Subject: RE: Planning Consultation on A/132/19/DOC

Engineers Comments Regarding Surface Water Drainage

Condition 4: Surface Water Drainage

CGS civils Consulting Civil Engineers			
CLIENT GD GROUP			
ARCHITECT CITYZEN			
JOB TITLE MERRY ENGLAND ANGMERING			
DRAWING TITLE CONSTRUCTION DETAILS SHEET 1 OF 2			
DRAWN LH	ENGINEER	CHECKED CS	APPROVED
DATE SEPT 2019		SCALE @ A1	1:20
JOB NO. C1249	STATUS P	DRAWING NO. 300	REV. P2

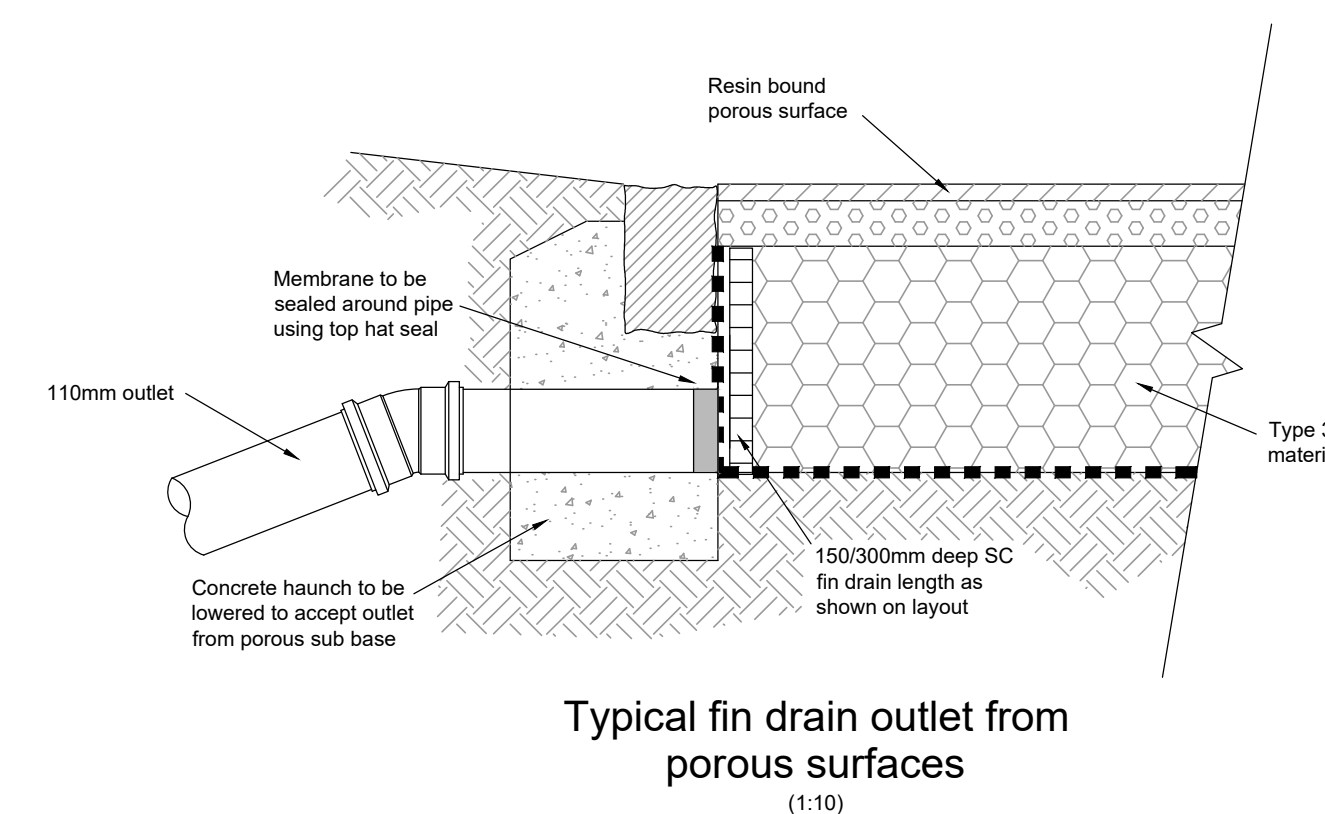
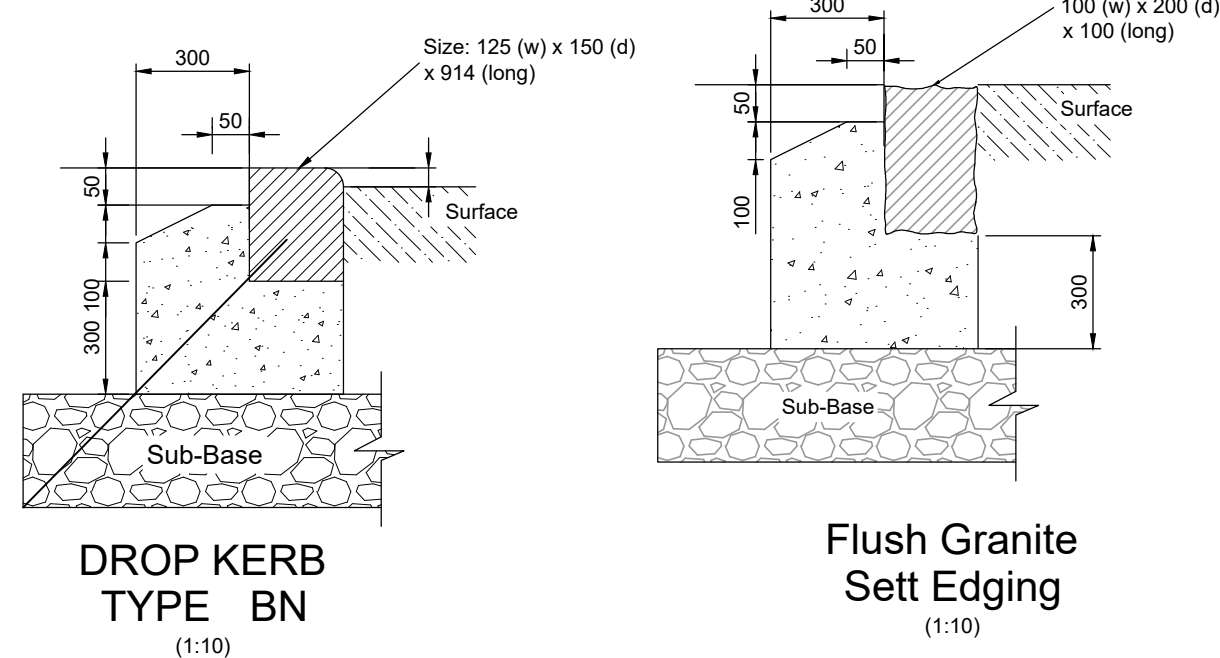
5. The attenuation tank detail should show one pipe for flows both entering and leaving the tank at the base. A vent pipe is required for the smaller tank. -- Noted and adjusted Fine

8. Buoyancy calculations are required for both tanks – the only mention of these is that they will be covered in a later addition. -- Email from structural engineer attached and 225mm thick slab added The calculations and detail are fine for the larger tank. What about the smaller one? -- This tank passed due to it being one cell high with additional cover material. Calcs attached.
